Rezoning Transportation Analysis

Petition Number: 2020-070

Reviewer: Eric Lemieux, PE
eric.lemieux@charlottenc.gov
704-336-2683

Date	Description
05-19-20	First Review
06-24-2020	Second Review (KP)

SHEET NUMBER  
**RZ-1**

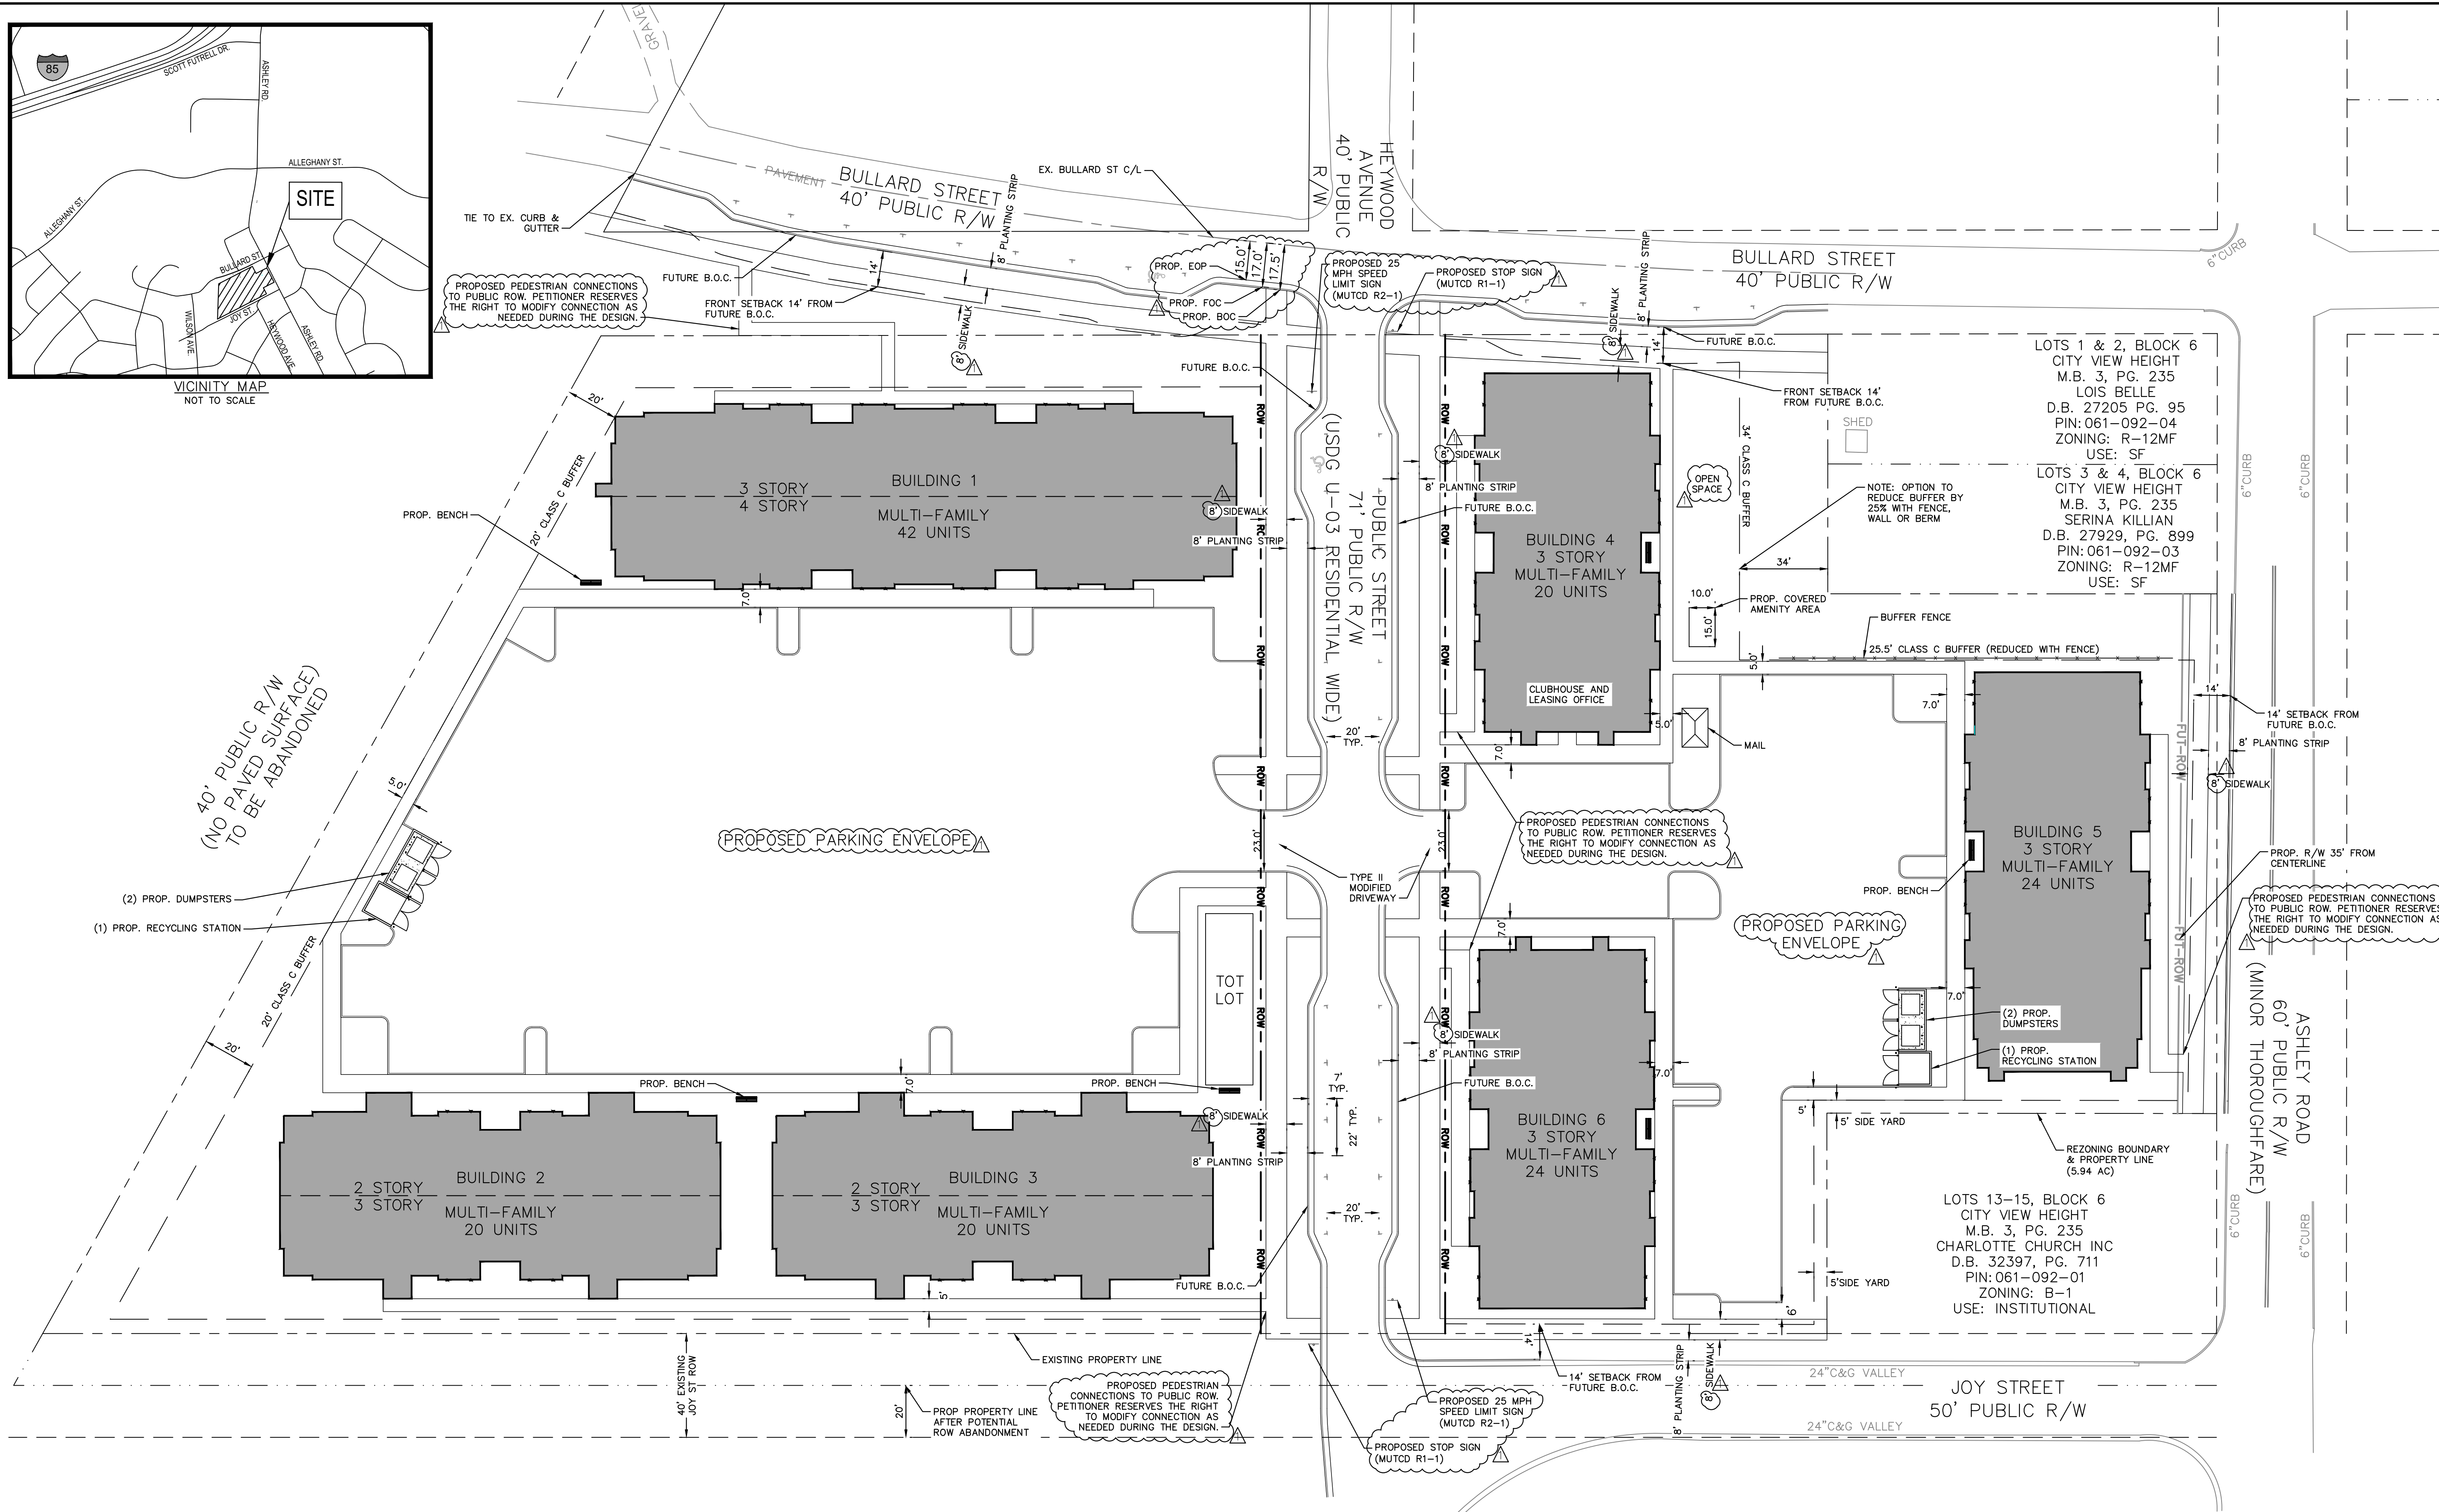
1. **Curblines** The proposed zoning district has a setback measured from back of the existing or proposed future curblines.
 - a. **Ashley Road:** The typical future location of curb and gutter is 21.5-feet from road center line to accommodate for one thru lane and a buffered bike lane, in accordance with the Charlotte BIKES council-adopted policy. **As discussed from the 06/22/2020 meeting please show the future and existing curb lines for reference and confirm that setback is from existing road centerline**

The site plan should show the curb and gutter labeled and dimensioned from the centerline for each road.
2. **Traffic Study** A Traffic Impact Study is not necessary for the complete review of this petition.

6. The petitioner should revise the site plan and conditional note(s) to provide a northbound left-turn lane at either the intersection of Ashley Road & Joy Street or Bullard Street & Joy Street.

12. **New comment:** To conditional Note III.8, please add language demonstrating that the constructed crosswalk will be a HAWK Signal. This was due to the speeds on Ashley Road.
